# ENG-PUDSP22001-R1-PDR.pdf Markup Summary

PUDSP221

# MAP POCKET

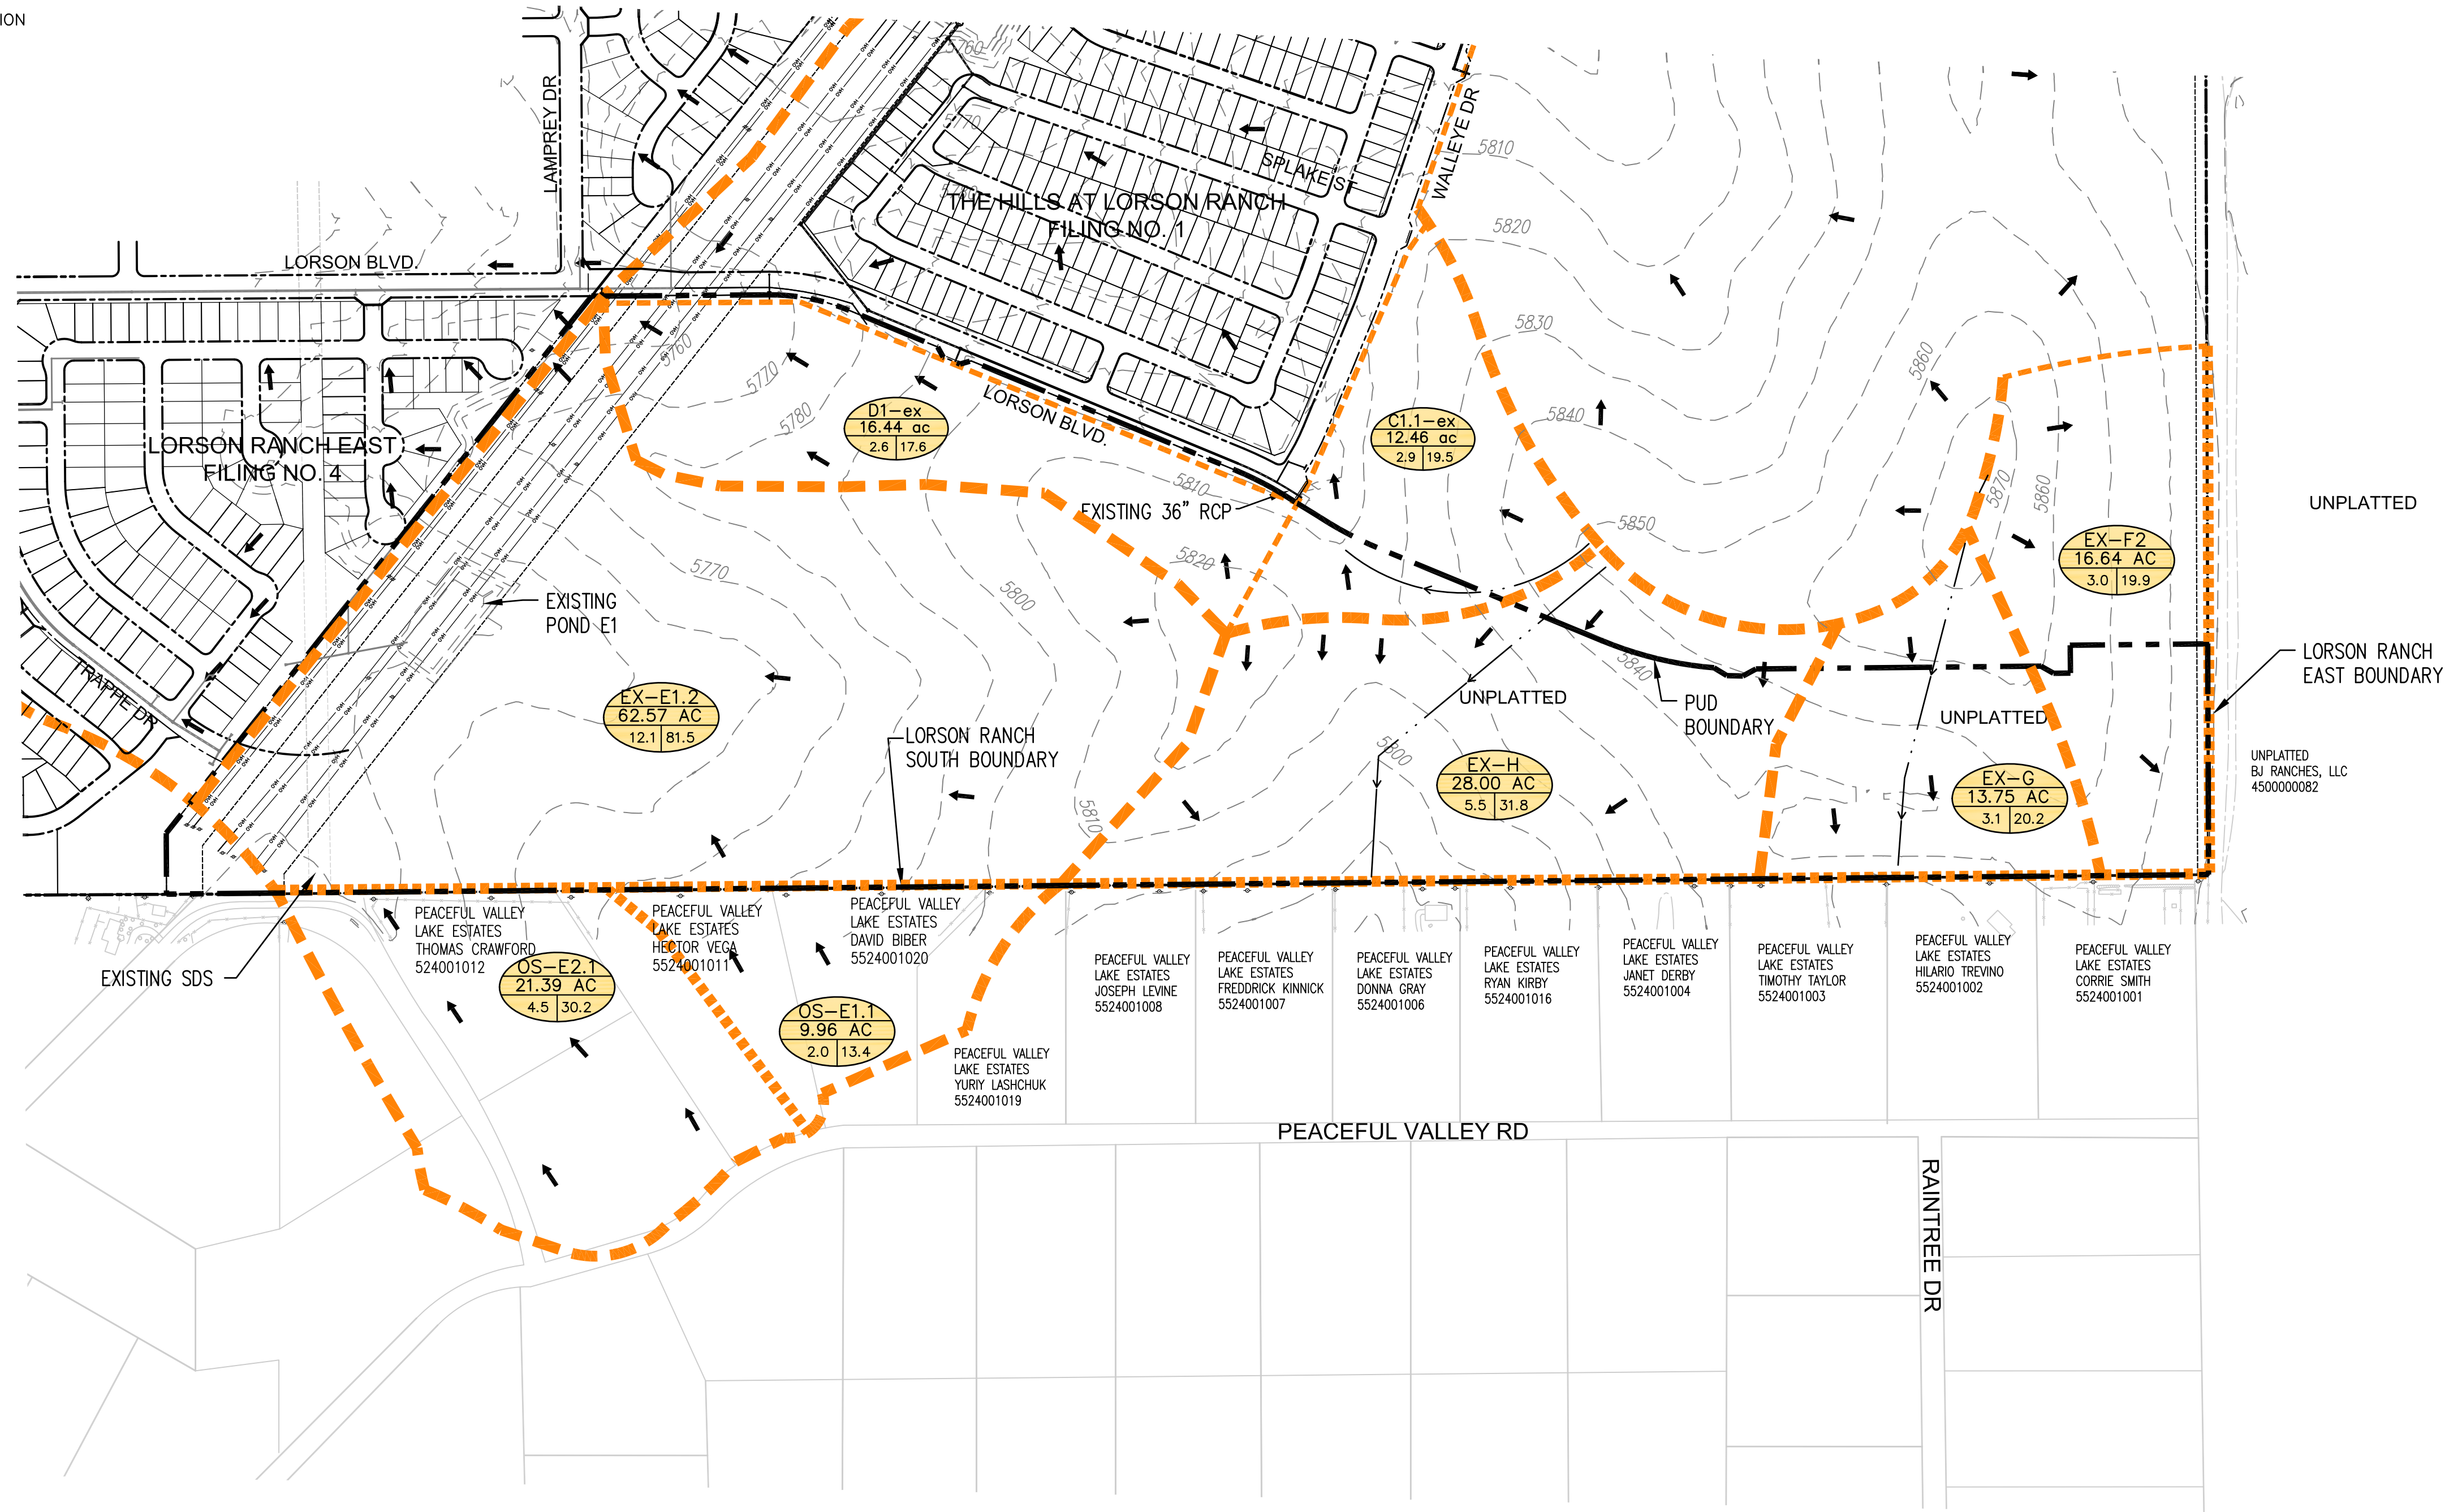
If there are any areas that are not treated by a PBMP, please delineate and properly label them with the applicable exclusion labeled (ex: 20% up to 1ac of development can be excluded per ECM App I.7.1.C.1 and exclusions listed in ECM App I.7.1.B.#). A summary table on the current map would also be acceptable (example provided below). If no excluded areas, you can ignore this comment.

Runoff Reduction: Provide a figure showing all proposed UIA and RPA areas to be utilized for runoff reduction. All RPA areas will need to be within a no build/drainage easement and discussed in the maintenance agreement and O&M manual. Wetlands are not an acceptable RPA per the MS4 Permit and MHFD guidelines. Also make sure to show RPA limits on GEC Plans (not just FDR) so our SW inspectors know that these areas are to remain pervious and vegetated post-construction.

label as "Hillside at Lorson"

since these areas have separate RPA's they should be shown as separate columns on the runoff reduction calcs (on pdf pg 143)

Large lots may be excluded if imperviousness is limited to less than 10% (Exclusion E)

# THE HILLS AT LORSON RANCH

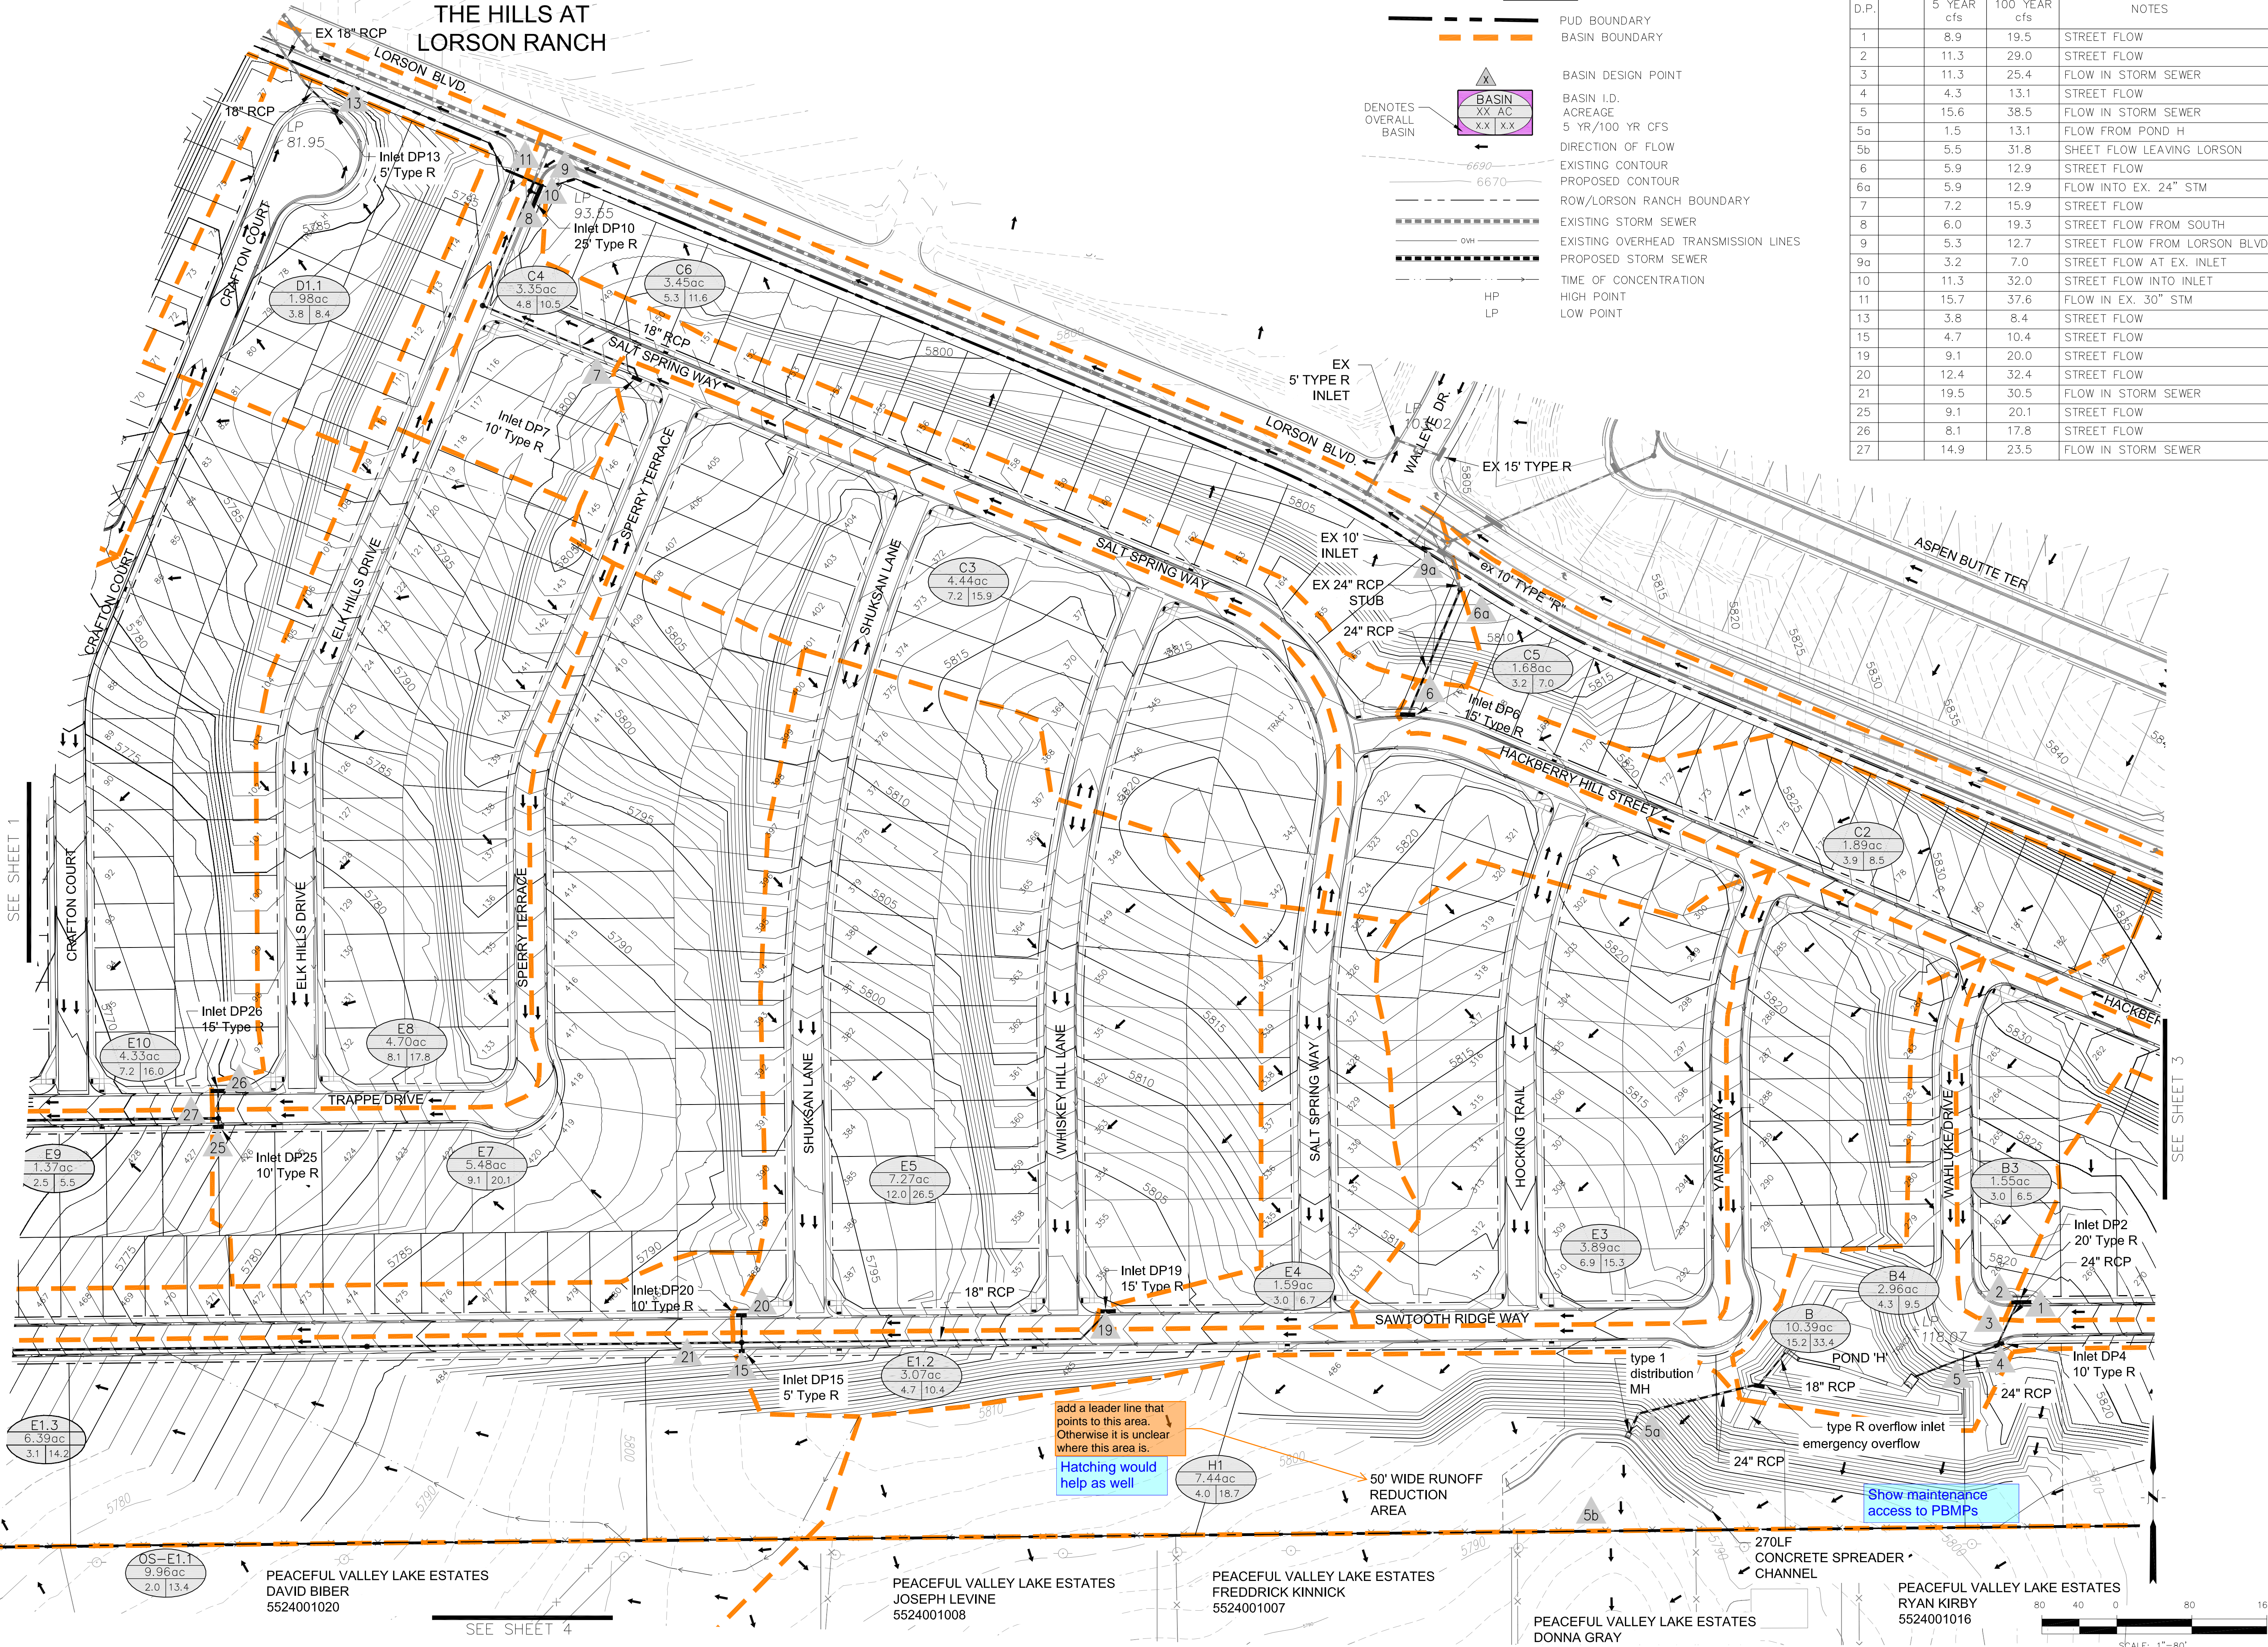
Label existing pipes and which pond it flows to (Hills at Lorson D2?)

connected?

Label to Pond C1

Label existing inlets -- DP47c and d?

Label D1.4

Add label for which pond this flows to (E2?)

Show maintenance access roads

DEVELOPED CONDITIONS  
HILLSIDE AT LORSON RANCH  
X

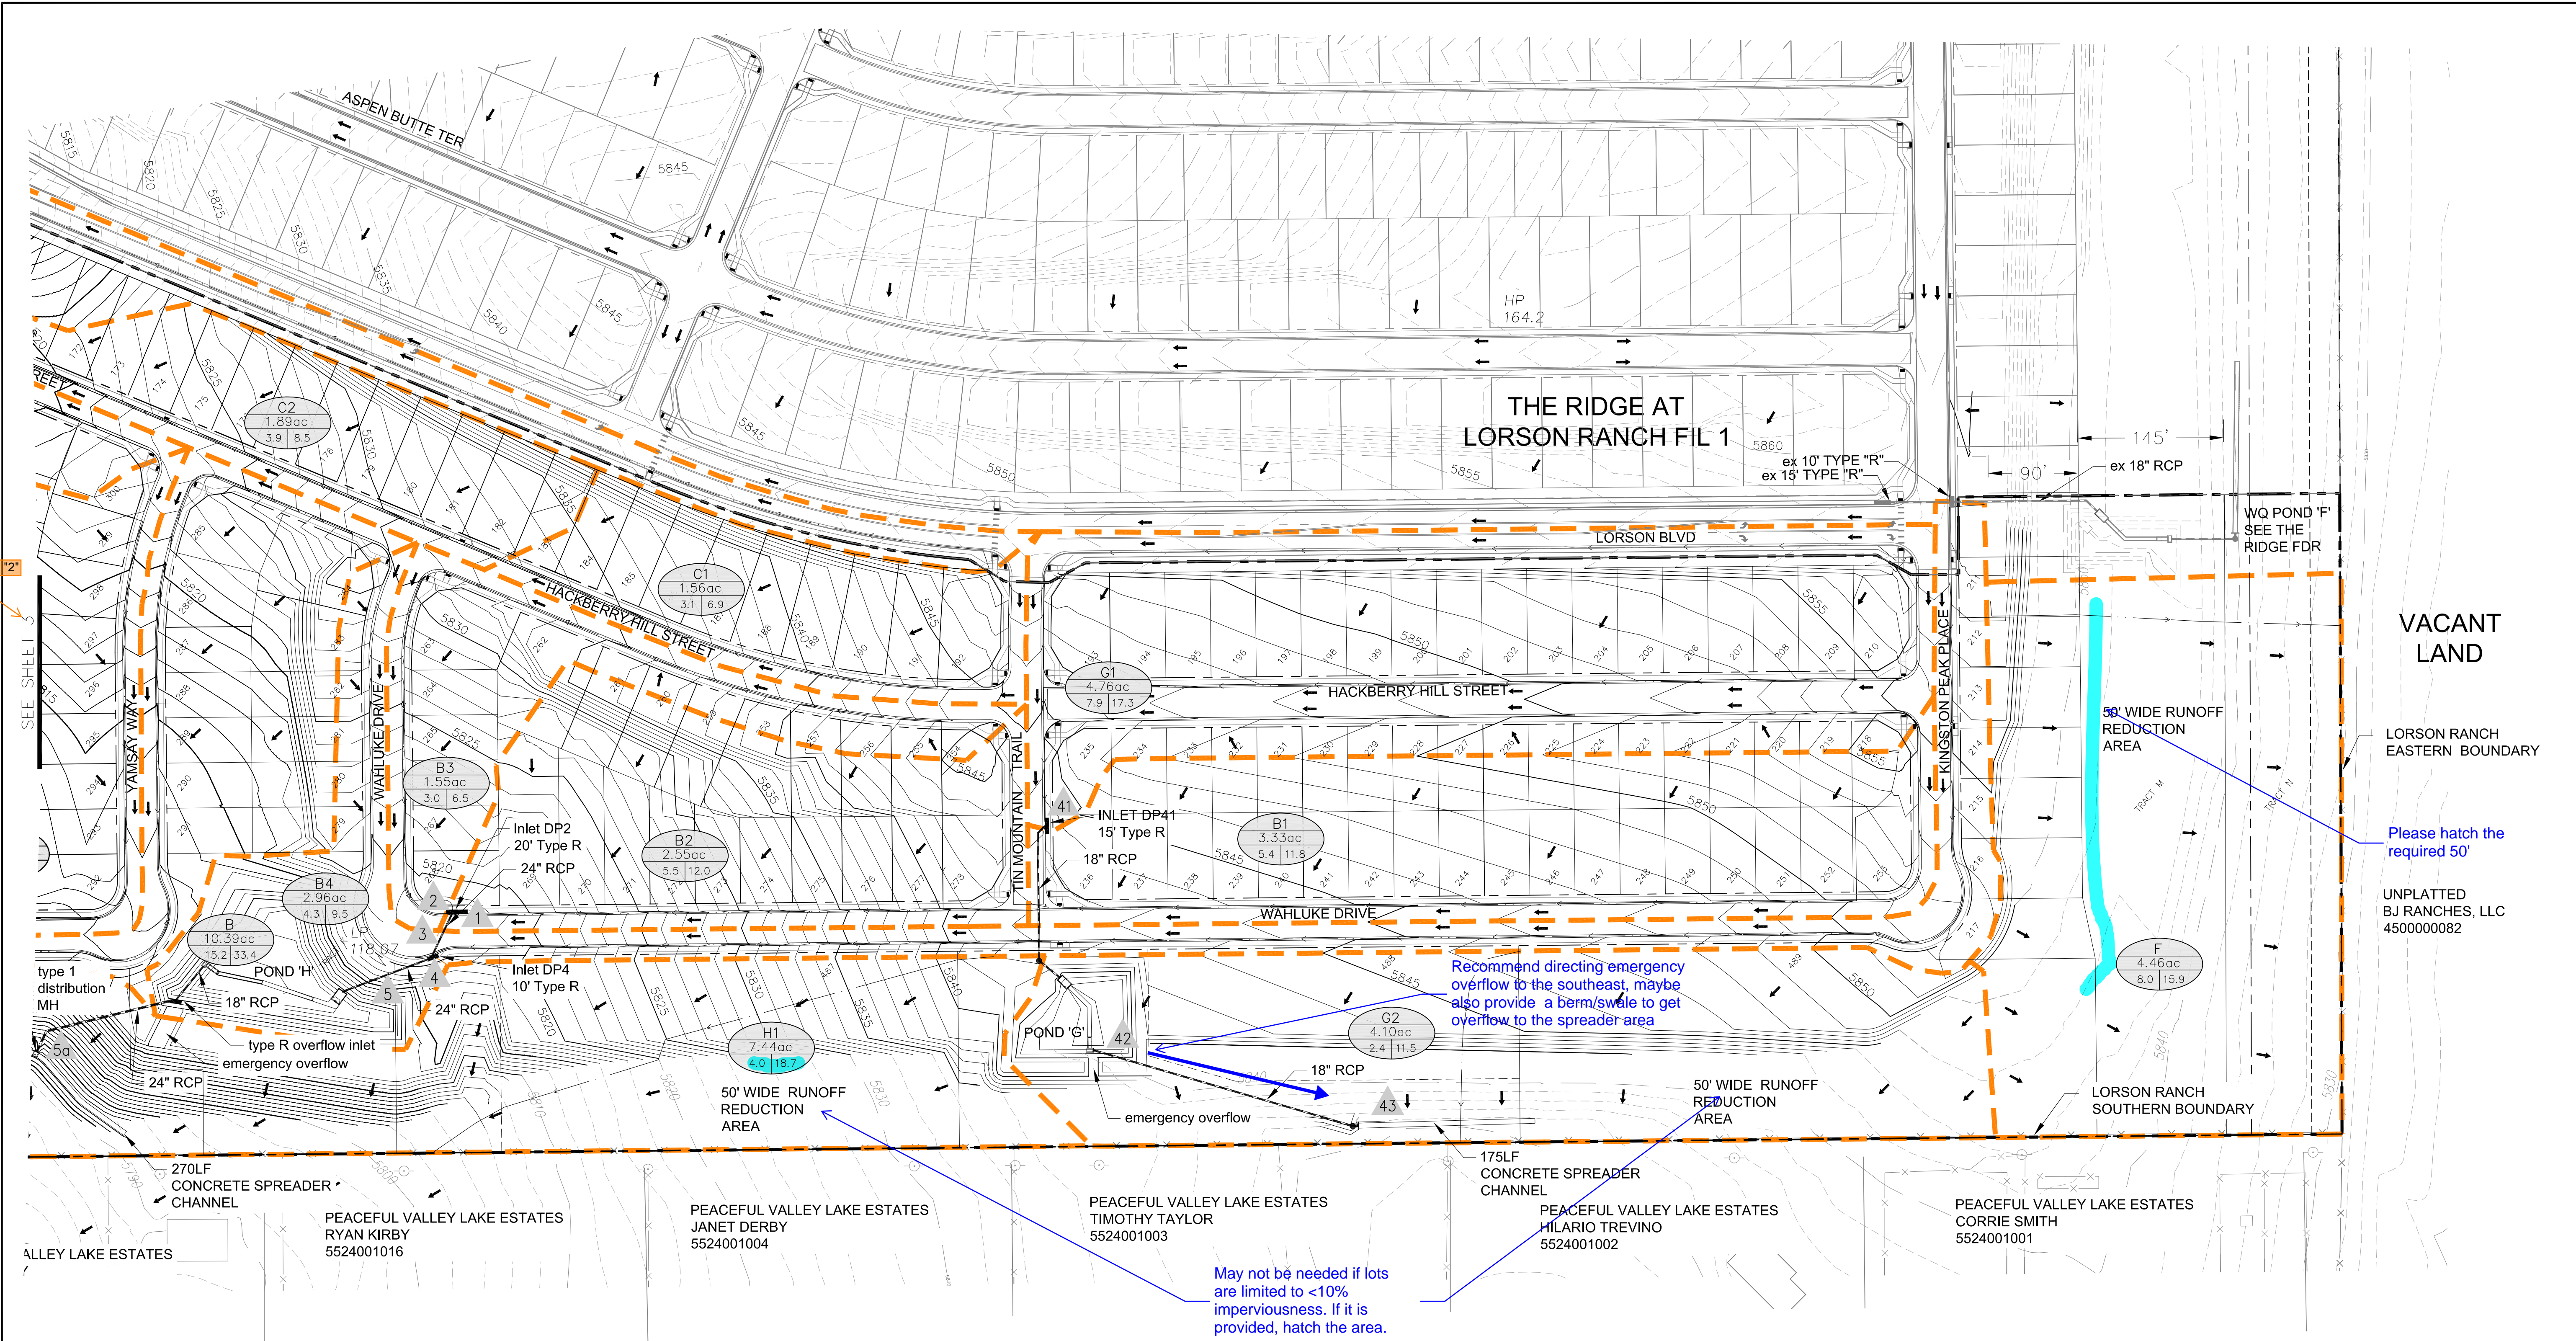
add a leader line that points to this area. Otherwise it is unclear where this area is.

Hatching would help as well

Show maintenance access to PBMPs
